BEALES HOTEL, COMET WAY, HATFIELD

PROPOSED SECOND FLOOR TO PROVIDE ADDITIONAL ACCOMMODATION INCORPORATING A GYMNASIUM

DESIGN AND ACCESS STATEMENT

ADDENDUM

Proposed Elevations A and B

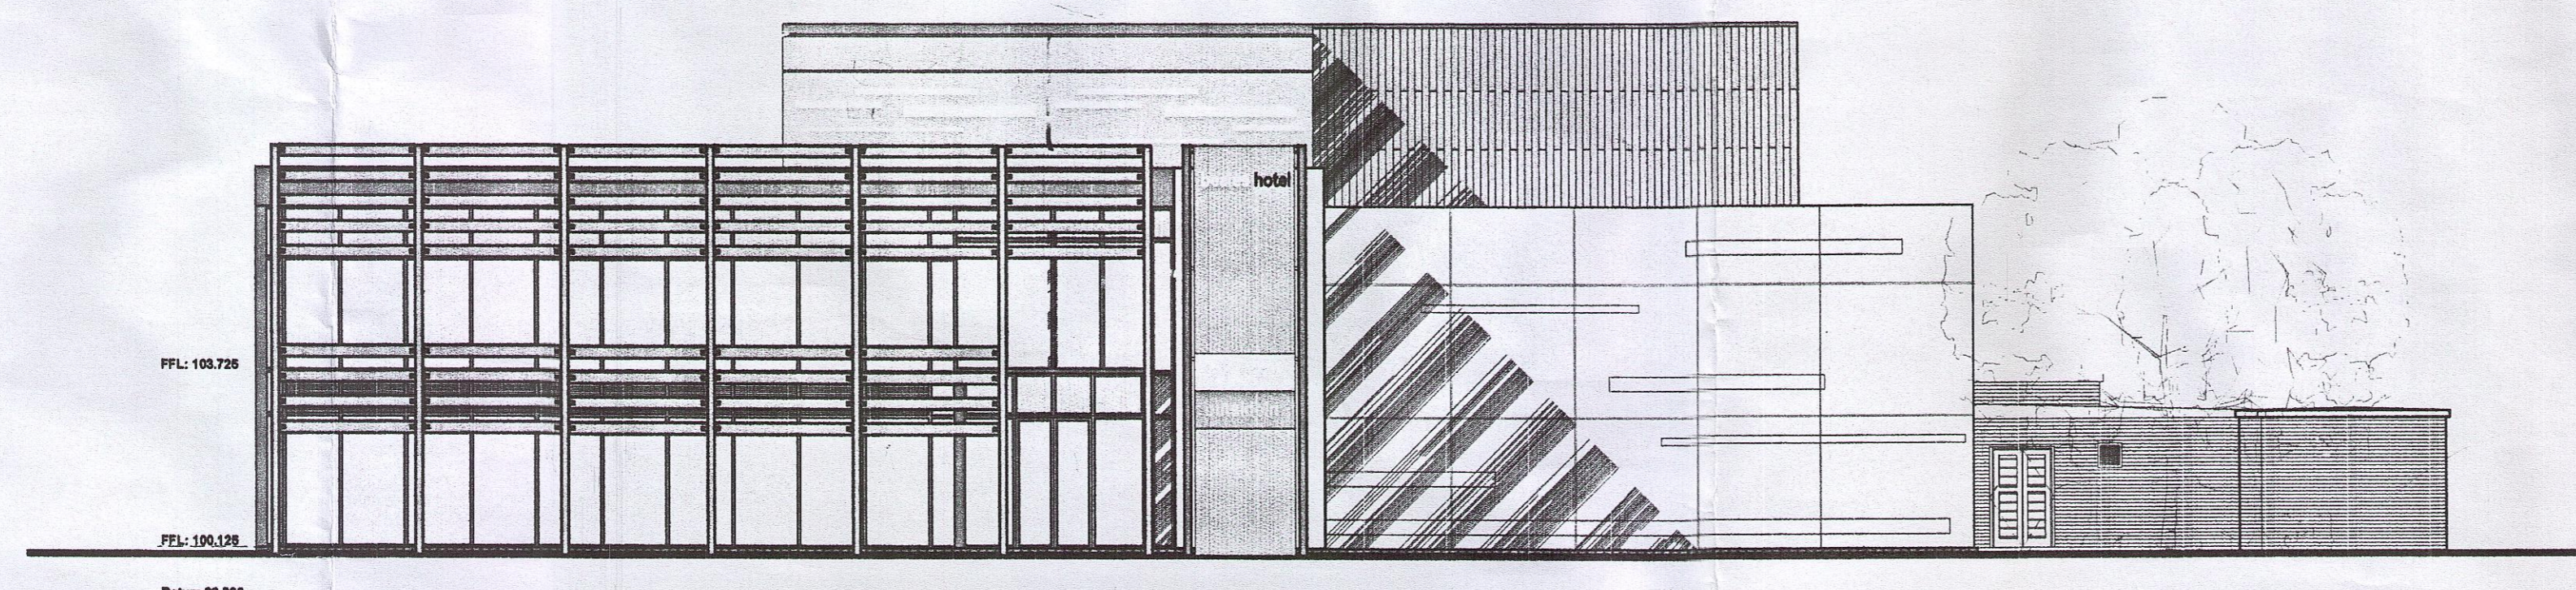
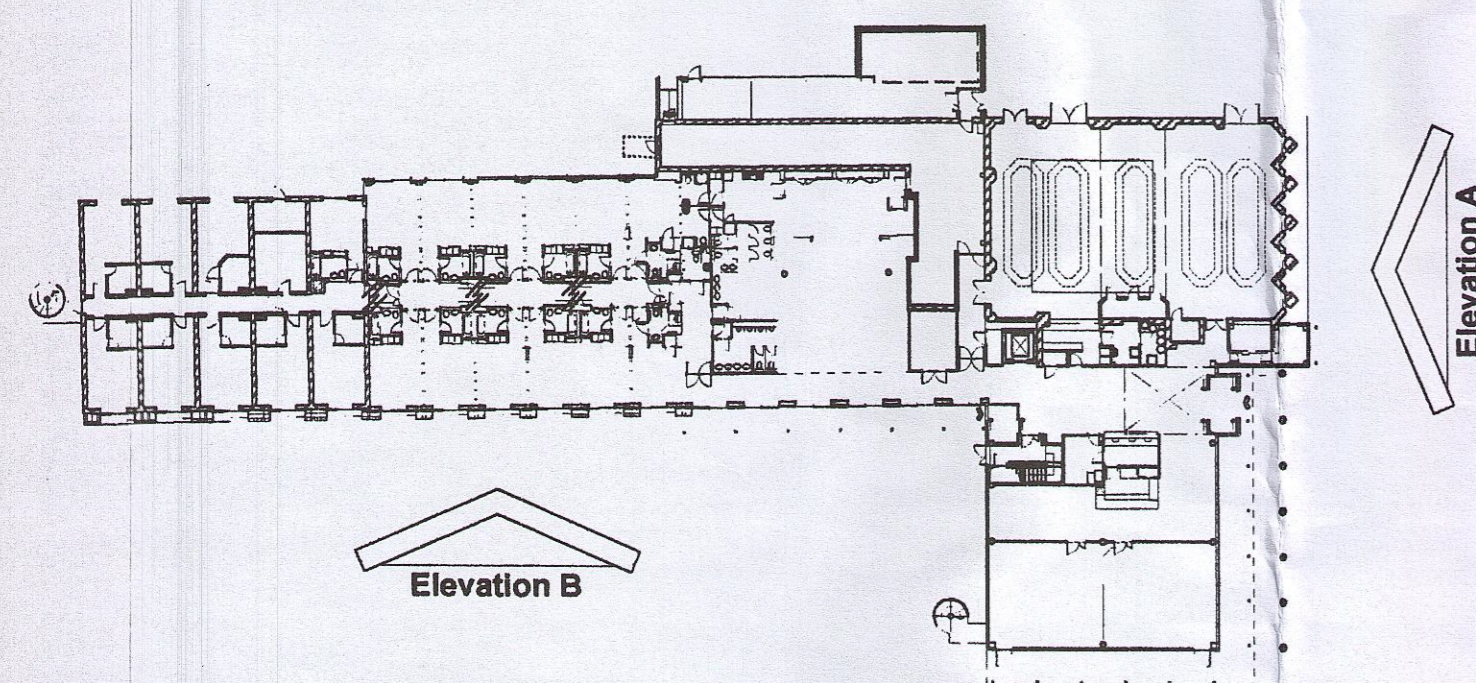
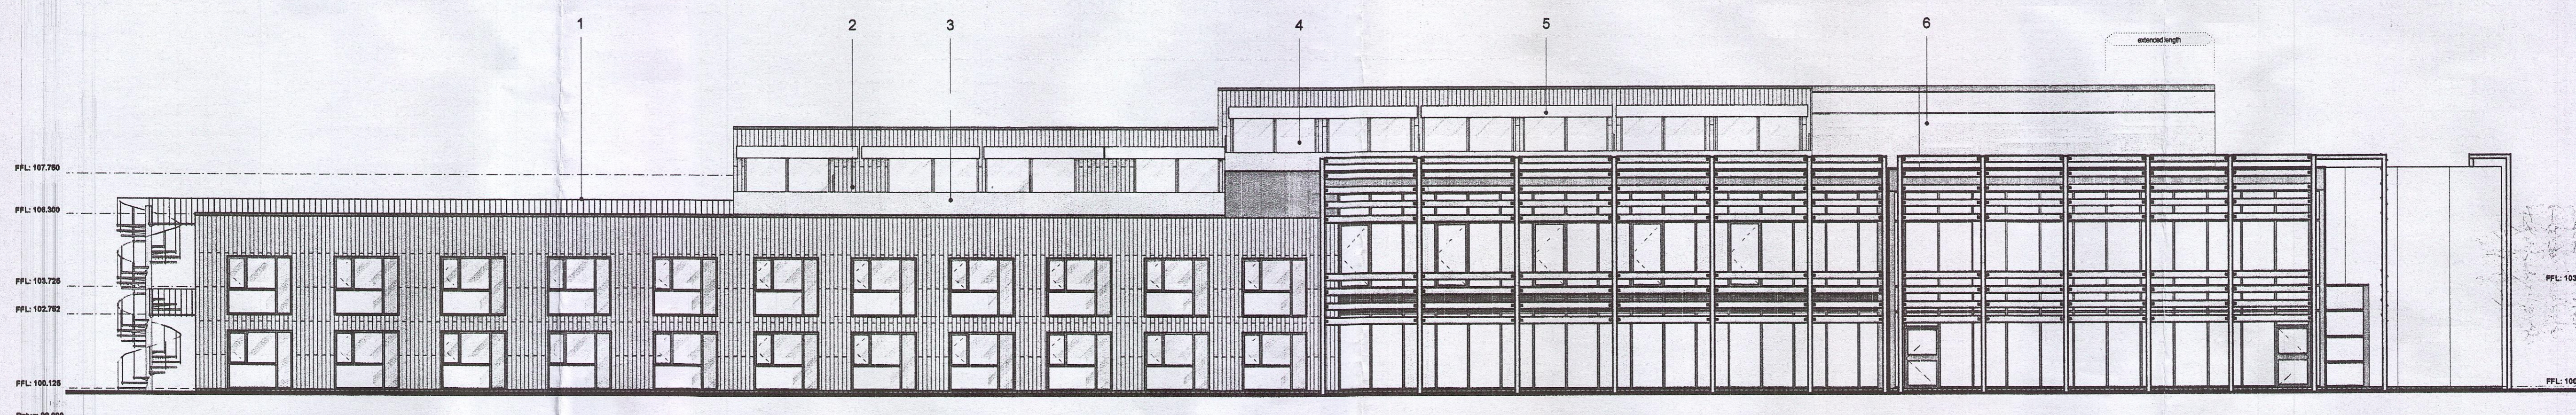
It is also proposed to increase the floor area of the gymnasium by approximately 74 square metres. This will involve a small increase in the massing at this level which is shown on attached drawing A05.229.P007D and elevations P008B & P009B.
